WELWYN HATFIELD COUNCIL – DEVELOPMENT CONTROL
DELEGATED REPORT

APPLICATION No:	S6/2009/2354/FP
------------------------	------------------------

The proposed development would comprise a first floor rear extension over an existing ground floor lounge area. The extension would have one window to the rear.

**Drawing Title**  
GENERAL ARRANGEMENTS  
ROOF PLANS  
EXISTING AND PROPOSED

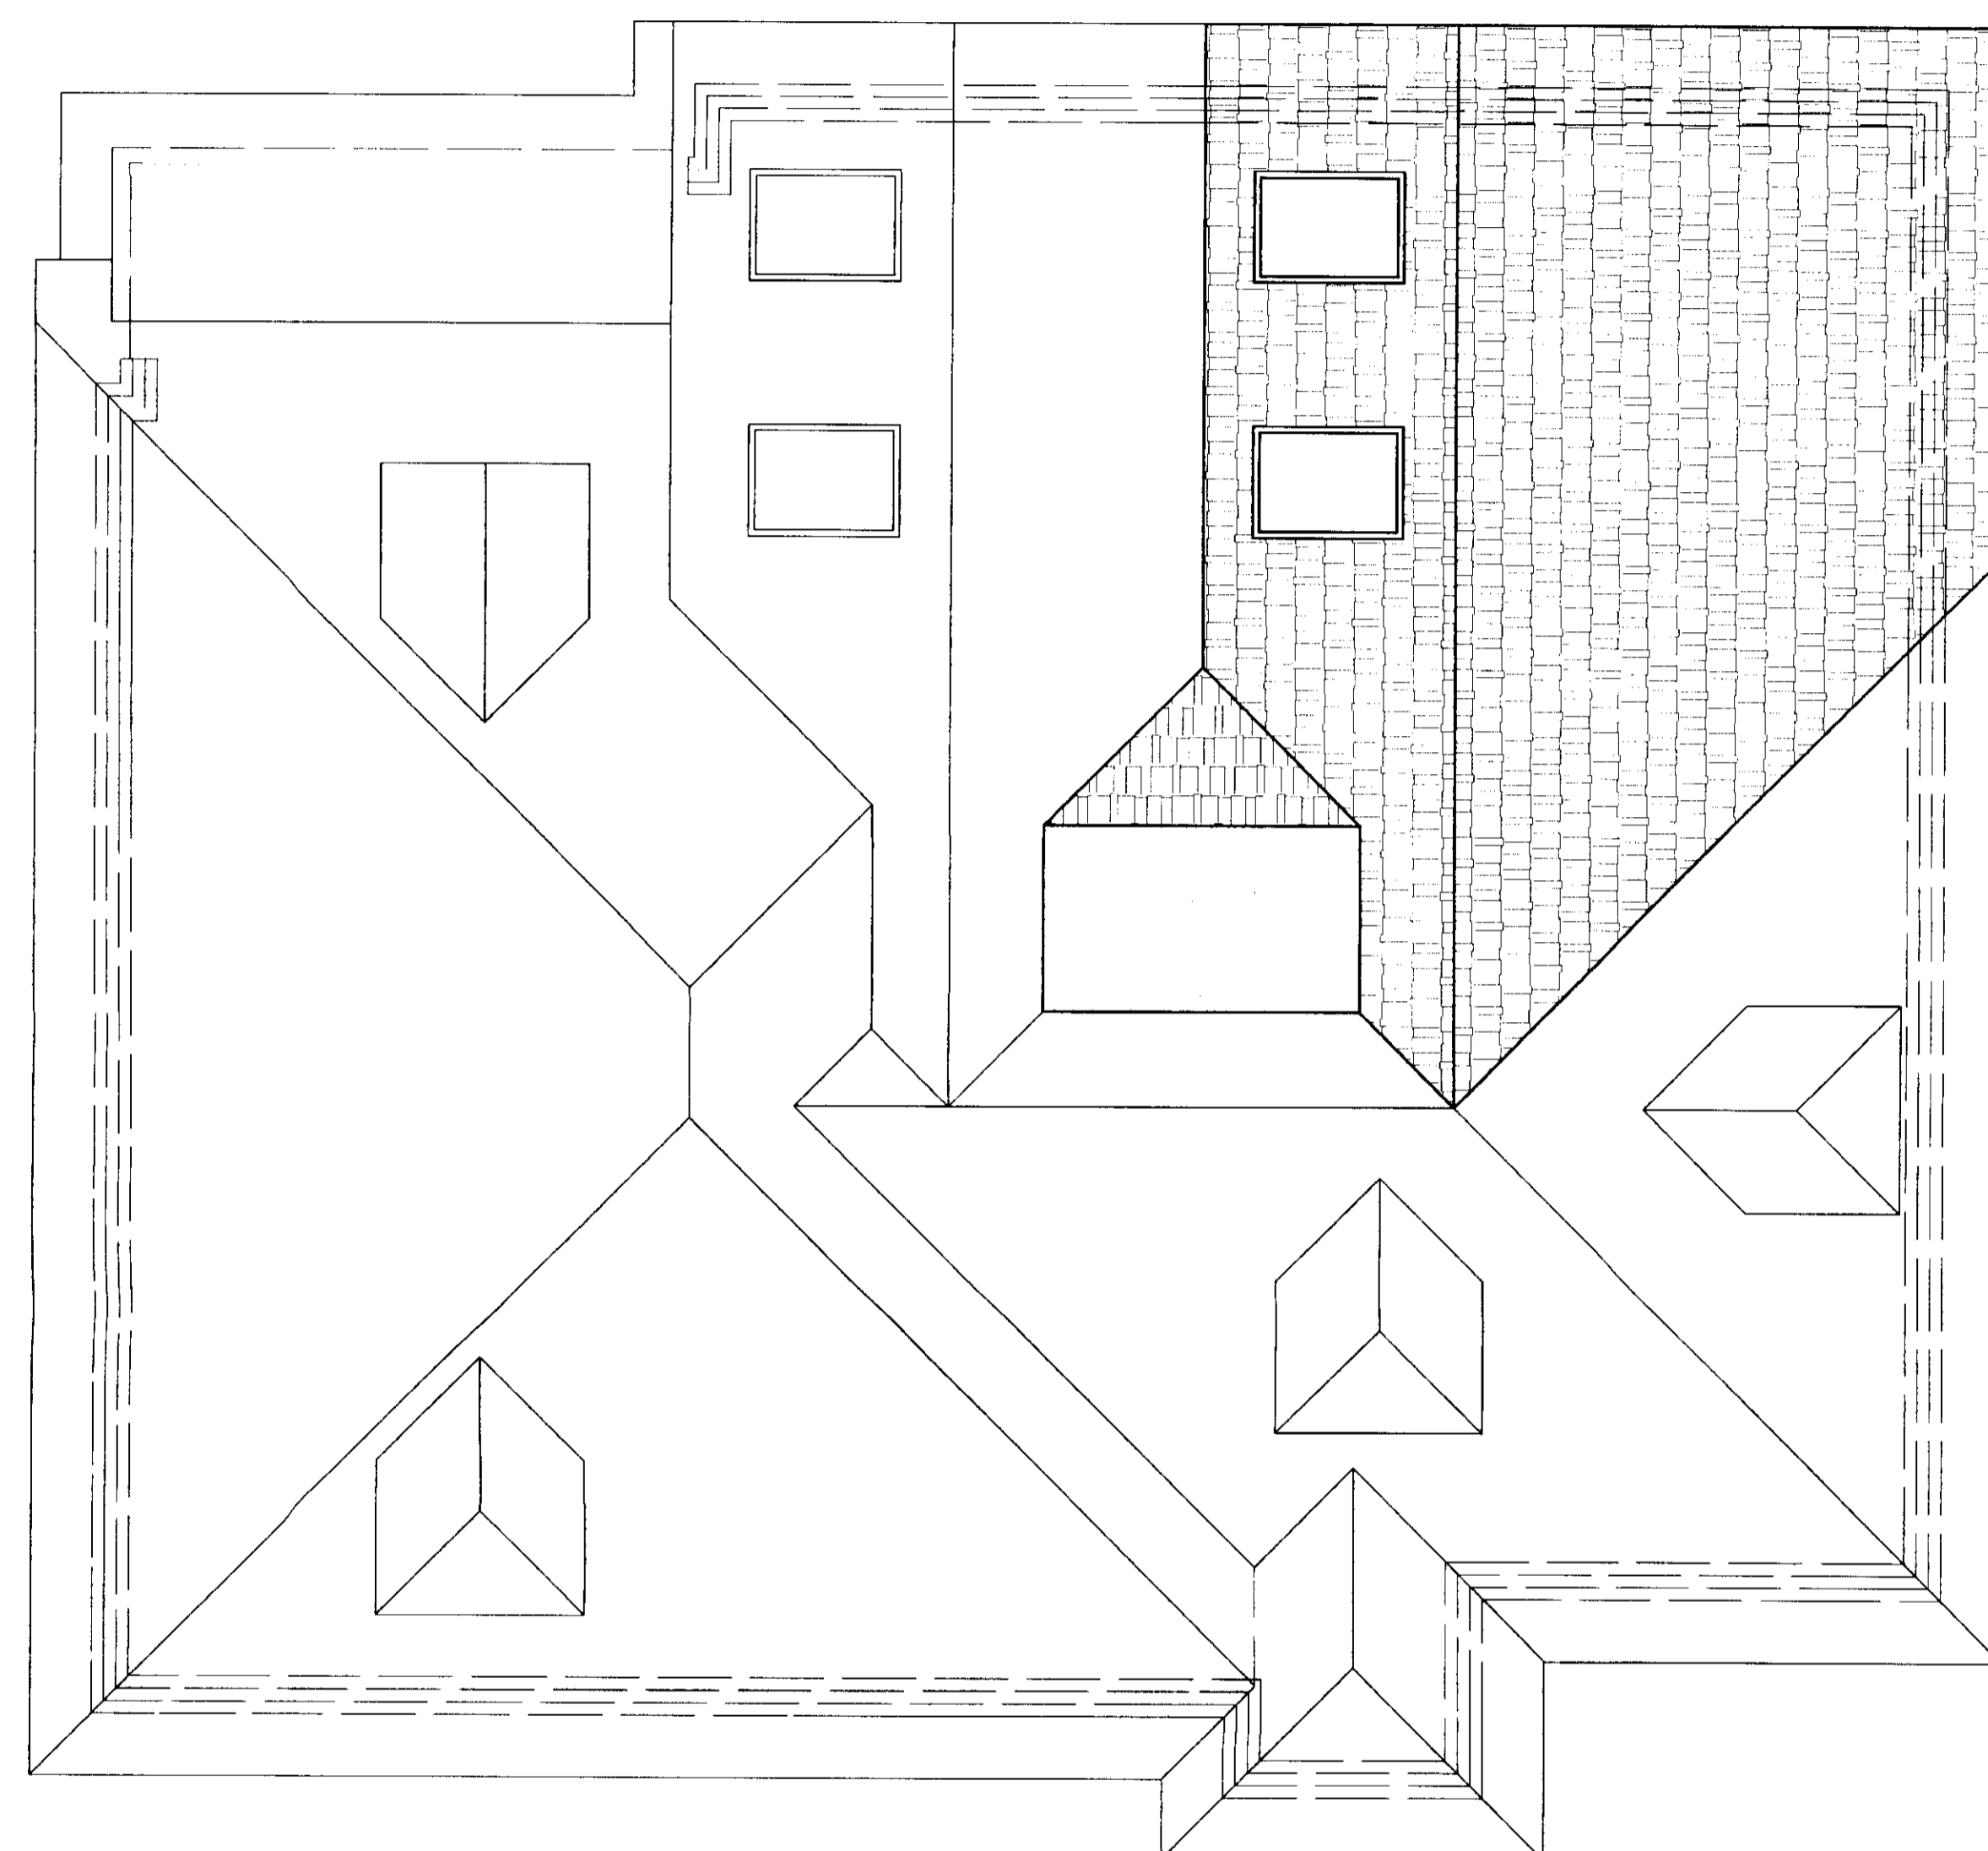
have a gable end style roof detail which was approved under the earlier in 2009. This design is considered to be in keeping with the character of the existing dwelling.
